May 25 2022

Re: PA22-017 – Marysville 172 – Technical Review 1

RE: Marysville 172, File# PA22-017
New Apartment Complex
1930, 2008 & 2104 172nd Street NE & Parcel #'s 31052900201200, 2600, 1100, 1200

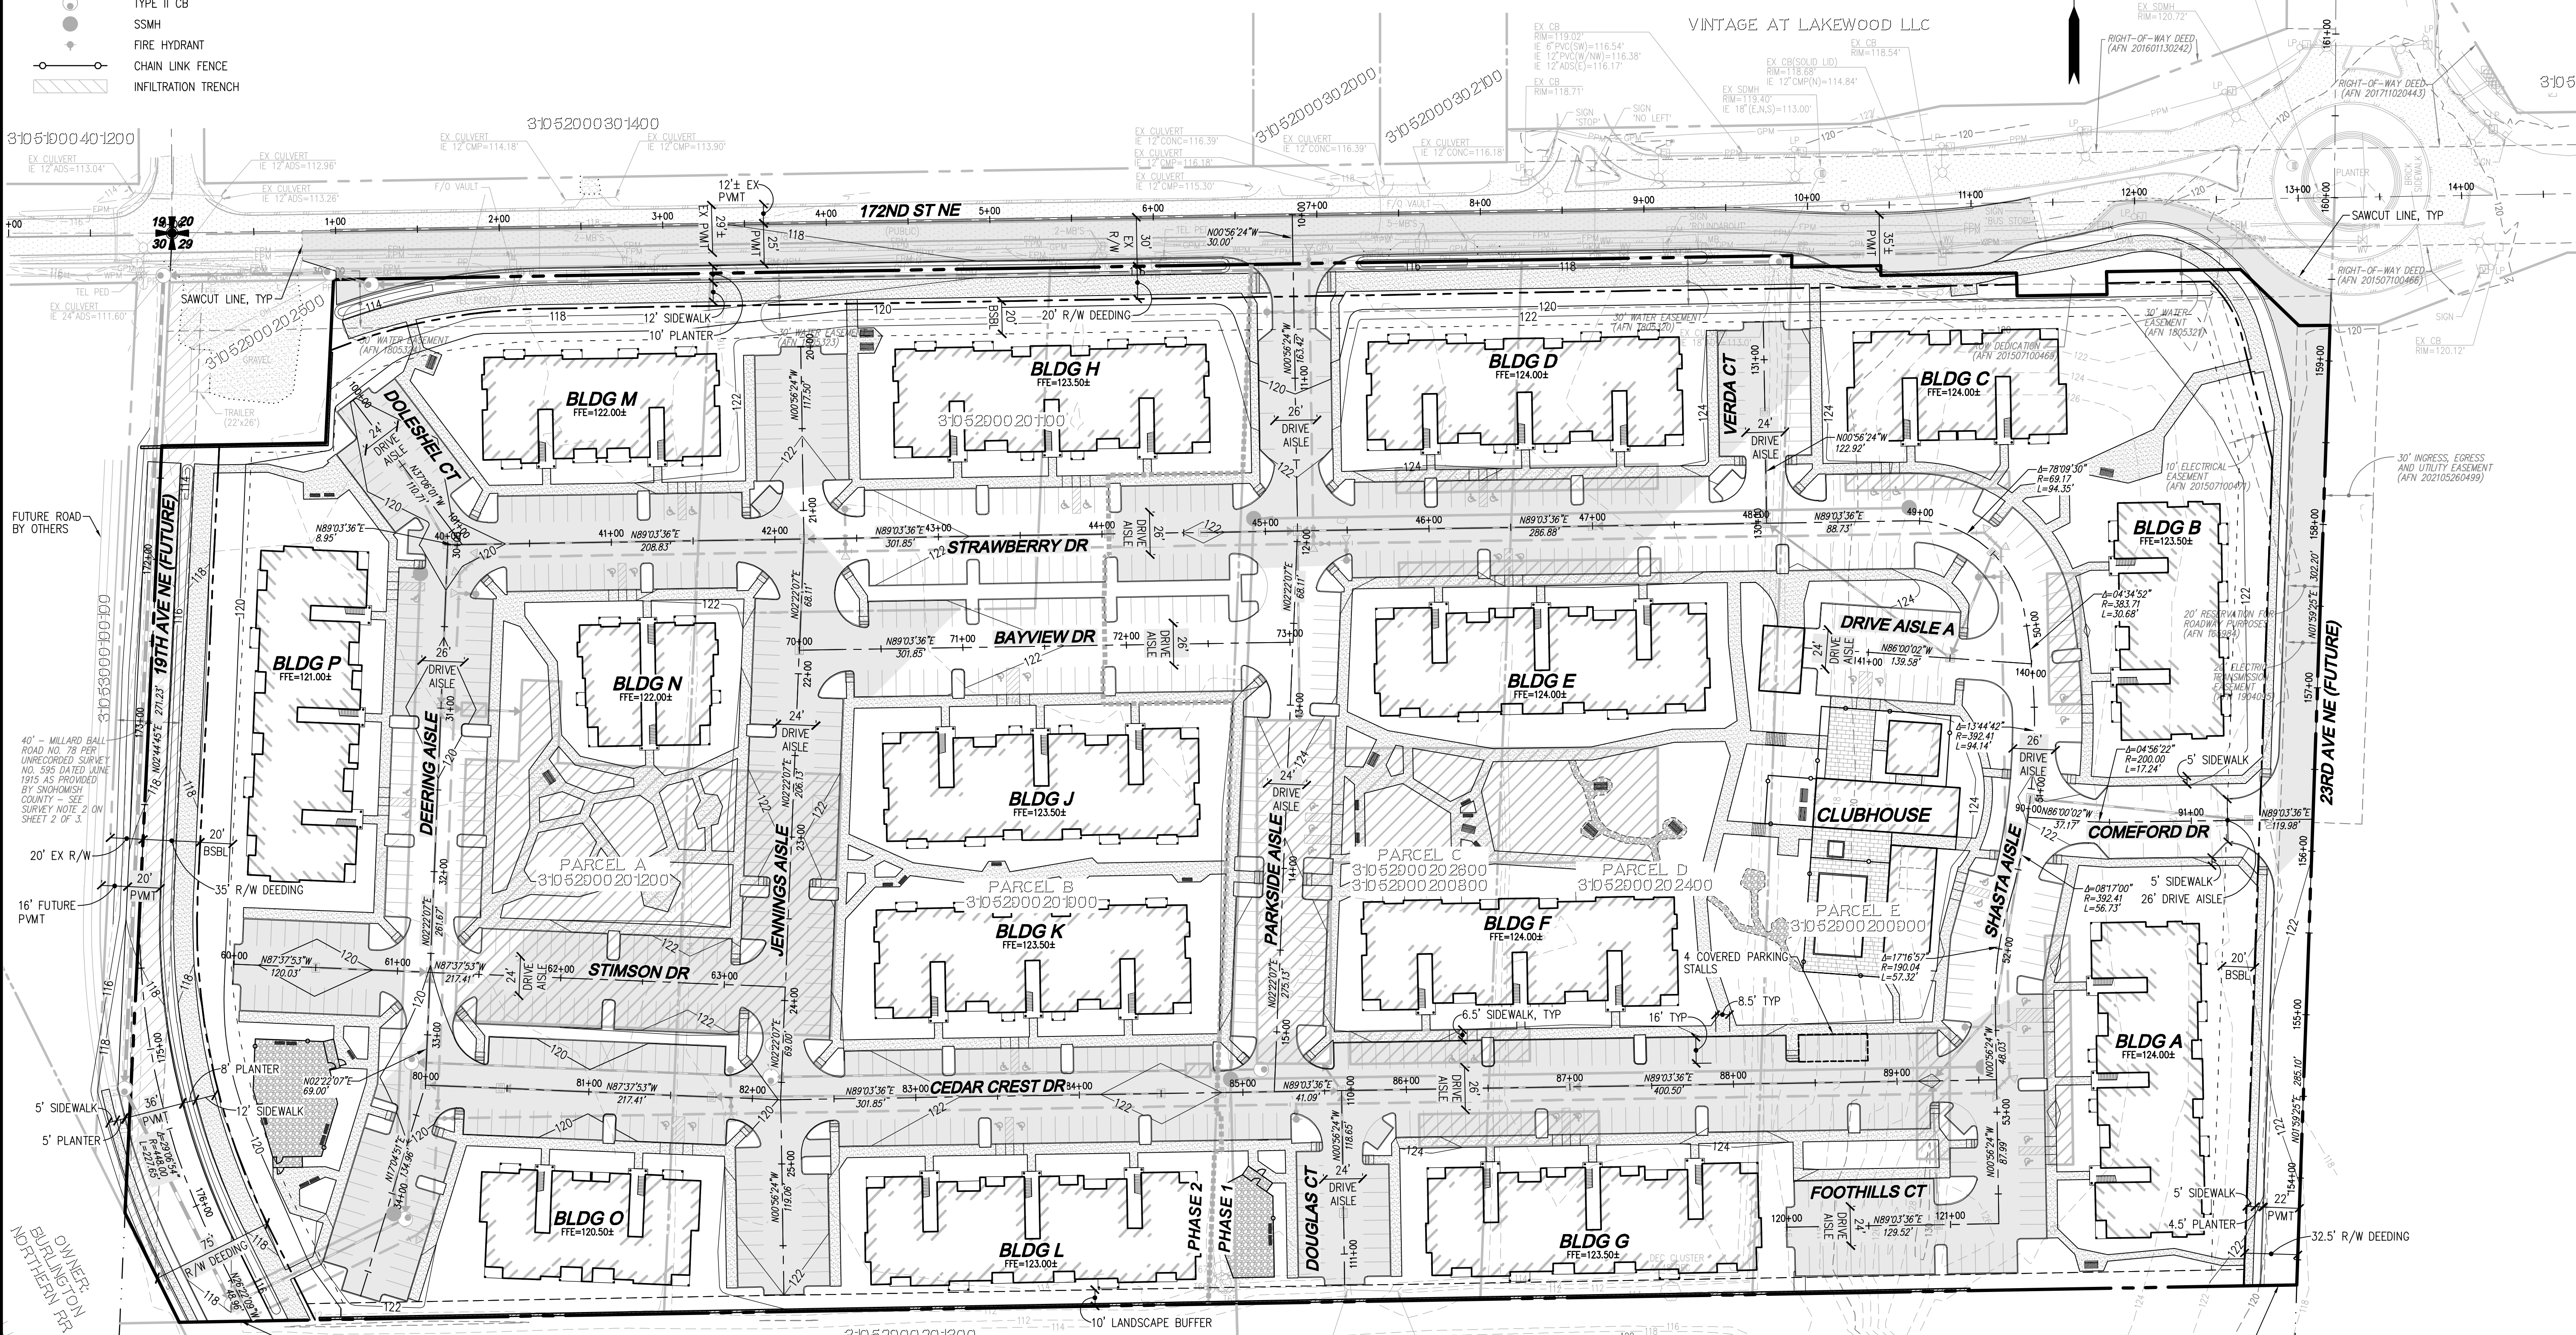
- 4.1. Based on the City's definition for Townhouse vs. Multifamily Dwelling Unit, the proposed development would be considered *Multifamily*.
- The proposed land use stated on CS-01 and SP-01 is *Townhomes*—please revise accordingly.

- 4.2. As referenced on the Civil Plans, the project is to occur in (2) phases. Revise plans to clearly show the dedicated areas of Phase 1 and Phase 2; the existing denotation is difficult to read.

- It appears that Buildings G & L may encroach into the required setbacks. Encourage a greater setback on the south property line, as a required 10 L1 Landscape buffer is required to be provided, which will likely take away all solar access to Buildings G, L & O.

- 4.4. Demonstrate compliance with impervious surface standards (75% maximum). Show calculation and total impervious surface percentages allowed and proposed.

L0.00

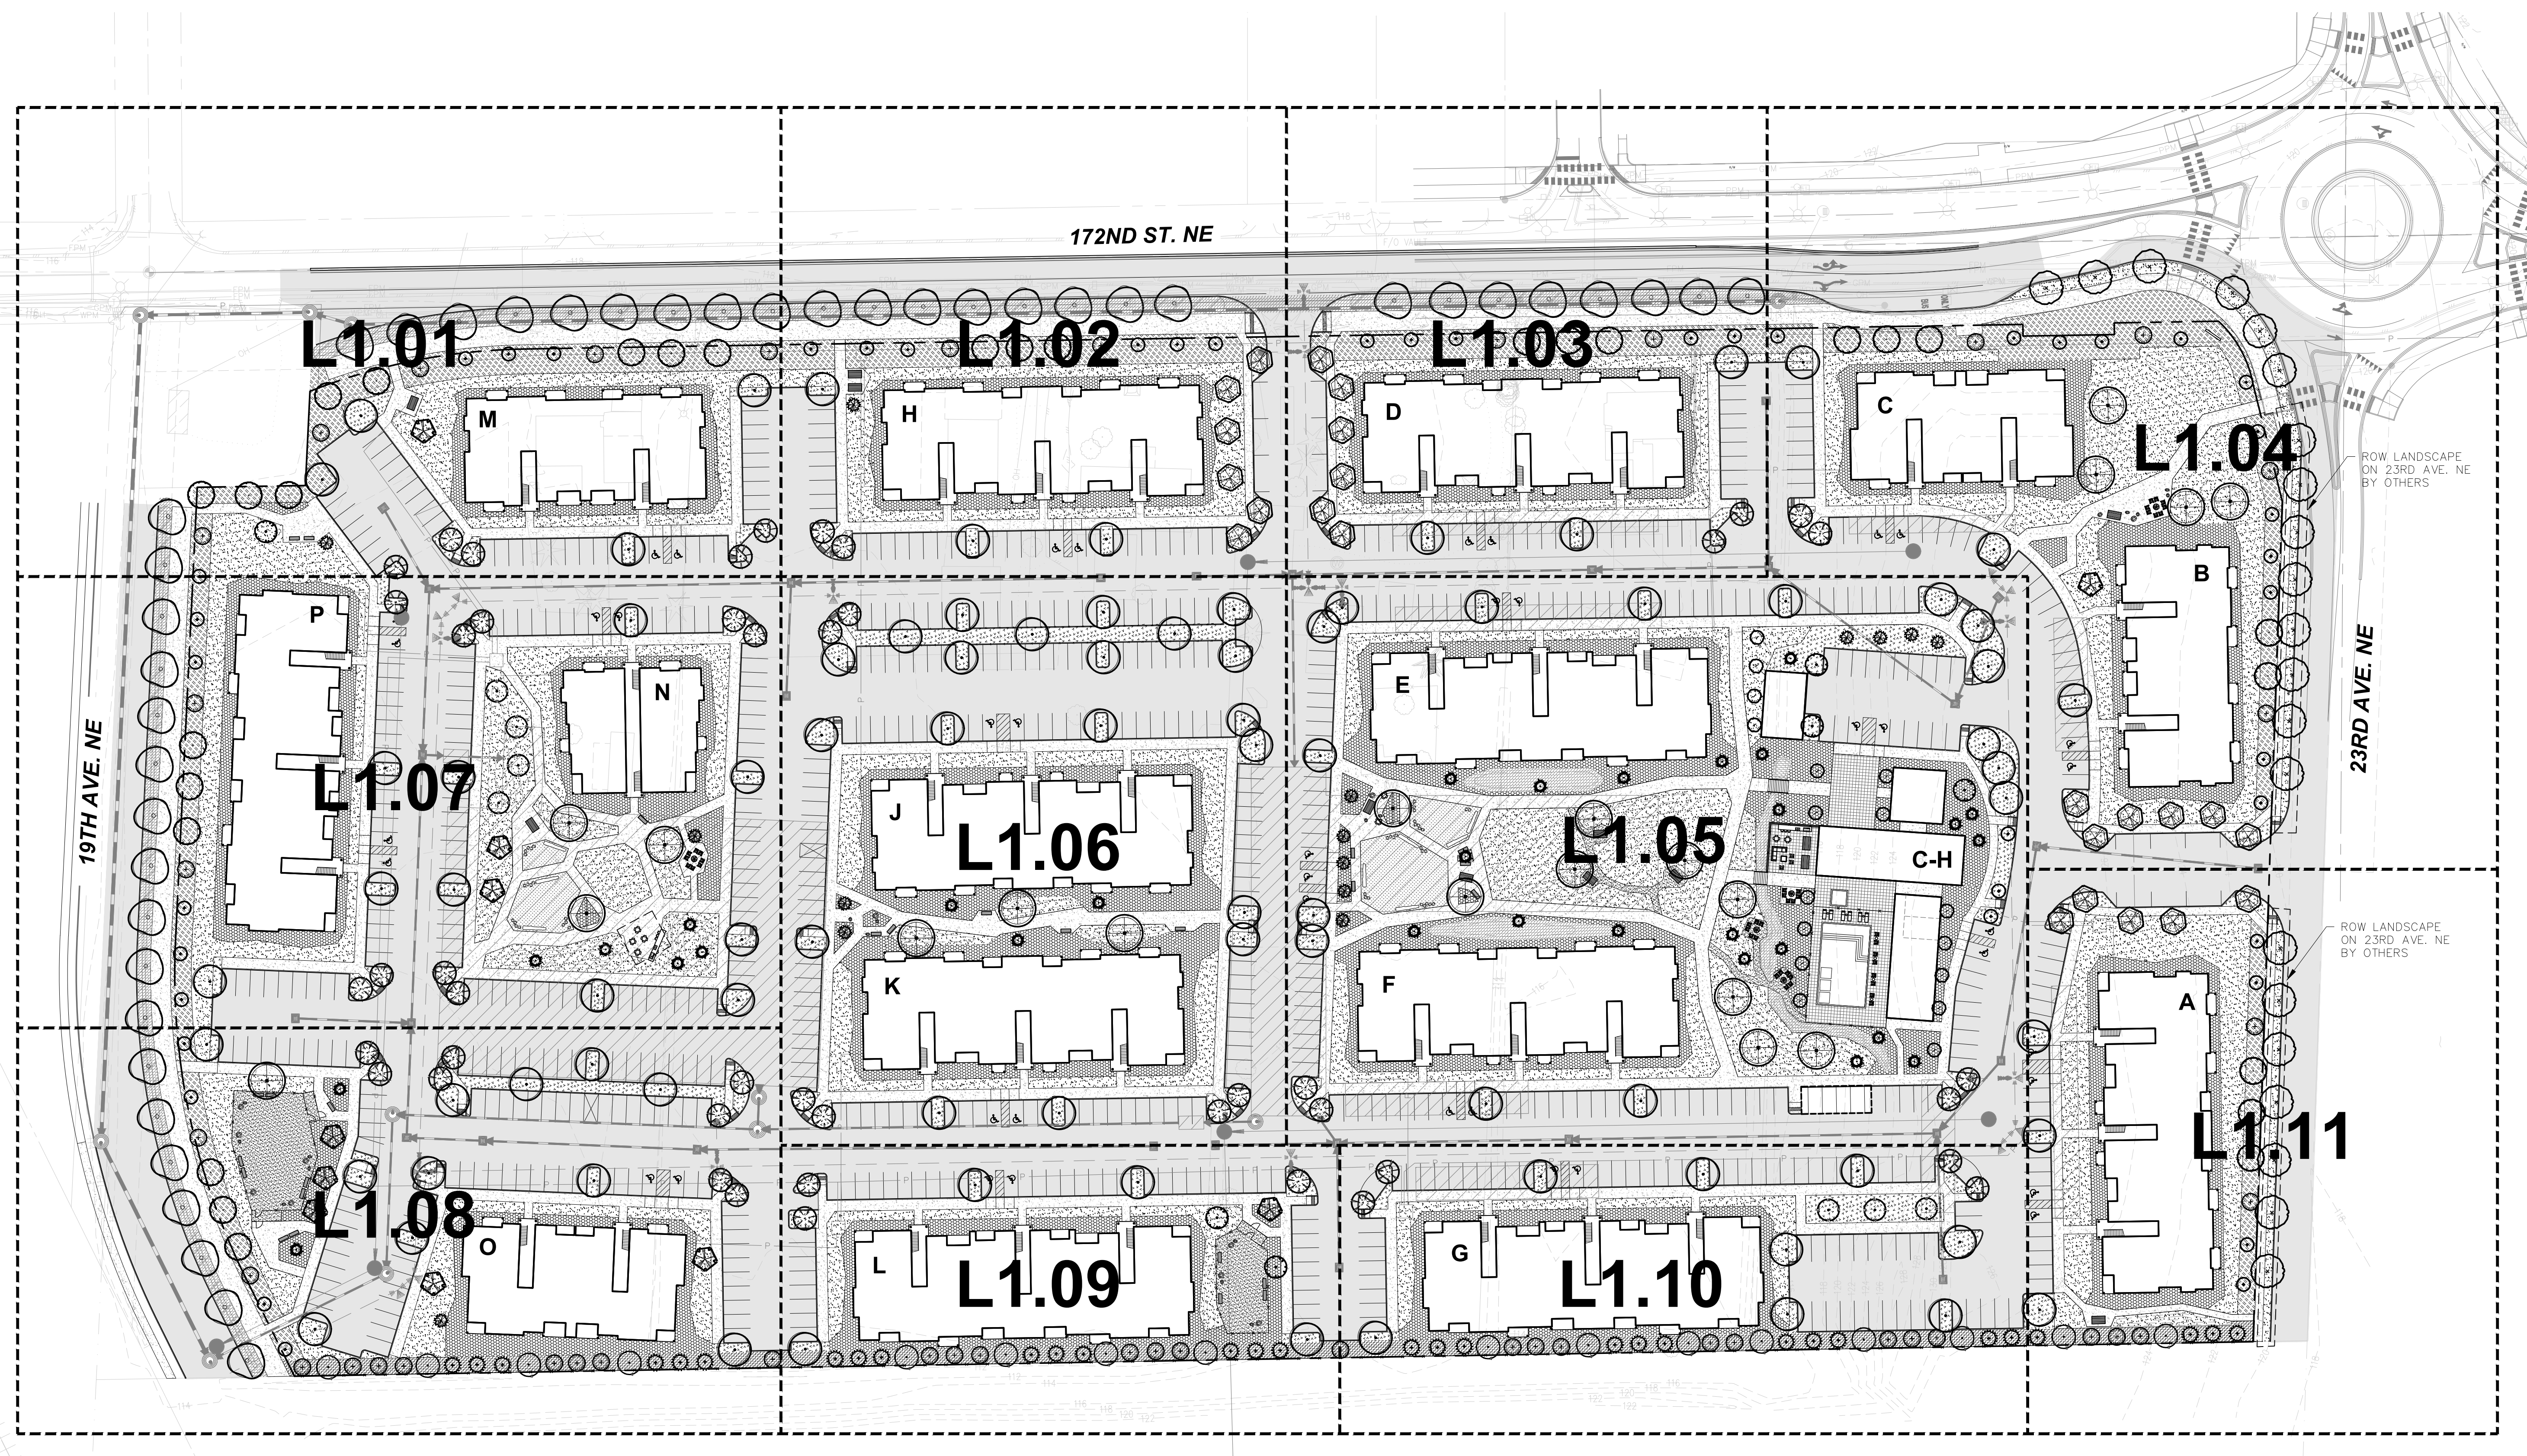
- As referenced on L0.00, the total residential open space provided is 107,529 sq. ft. However, the shaded open spaces areas total 103,084 sq. ft. Please revise and demonstrate compliance by providing these calculations. Further, please clarify which open spaces areas these shaded areas represent.

Color coding which open space and landscaped areas are which along with the associated calculations is encouraged.
